HOKO
85D Buckingham Road
Brighton
BN1 3RB

Please ask for: Ms Iqraa Malik
Email: iqraa.malik@terraquest.co.uk
Telephone: 0121 234 1390
Our Ref: LU/140/22/HH
Your Ref:
Date: 11th May 2022

Application for Planning Permission for Works or Extension to a Dwelling

Development: Single storey rear extension with flat roof and installation of 1 x side window.
Location: 19 Falcon Gardens Littlehampton BN17 7RA

3 BLOCK PLAN
1:200

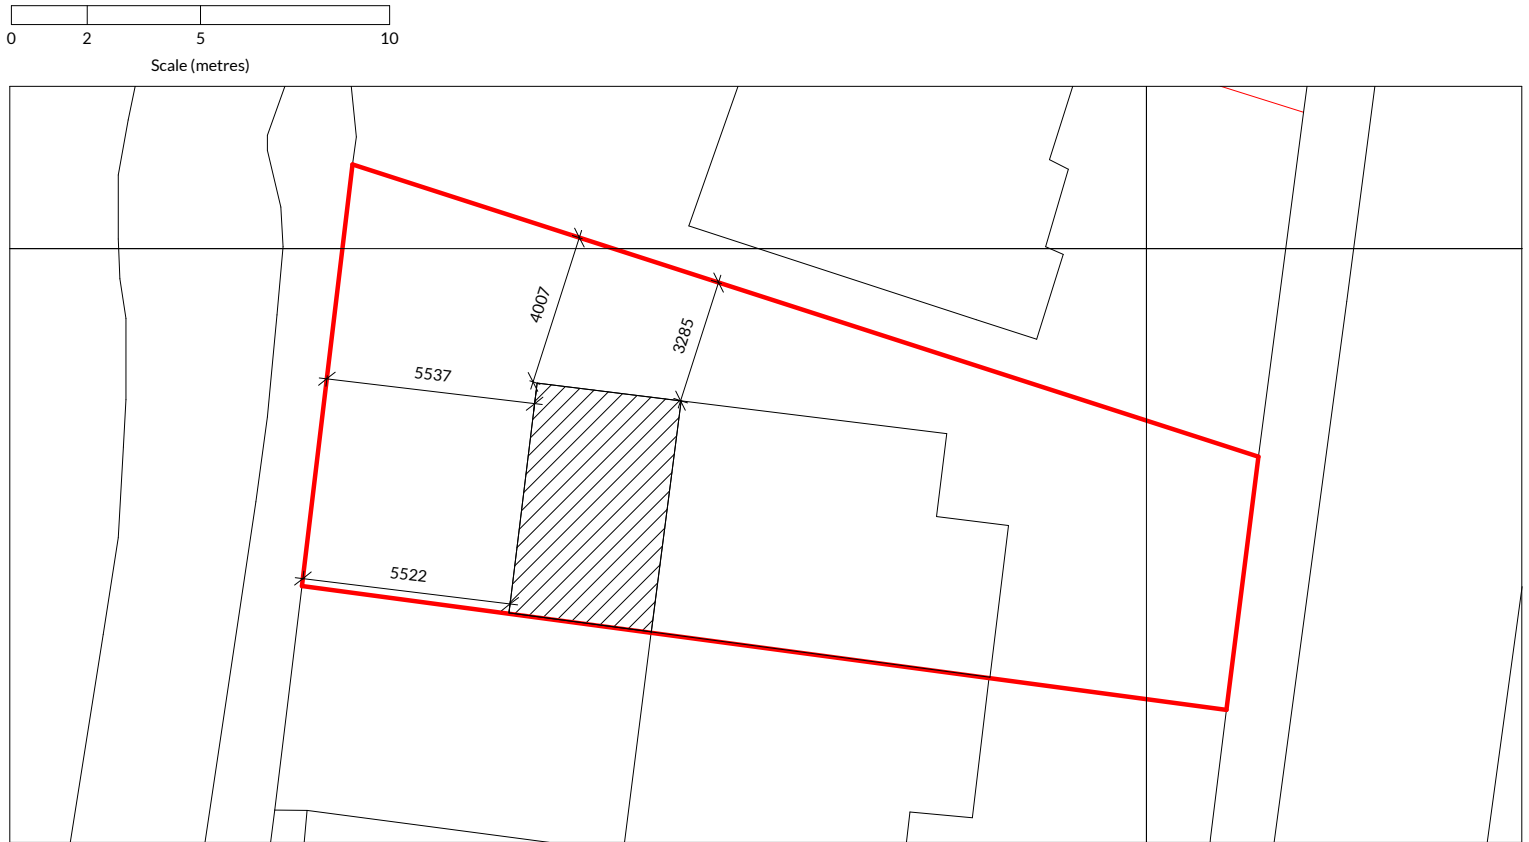
Block Plan

You are required to have dimensions from the proposed extension(s) to all site boundaries. Please amend.
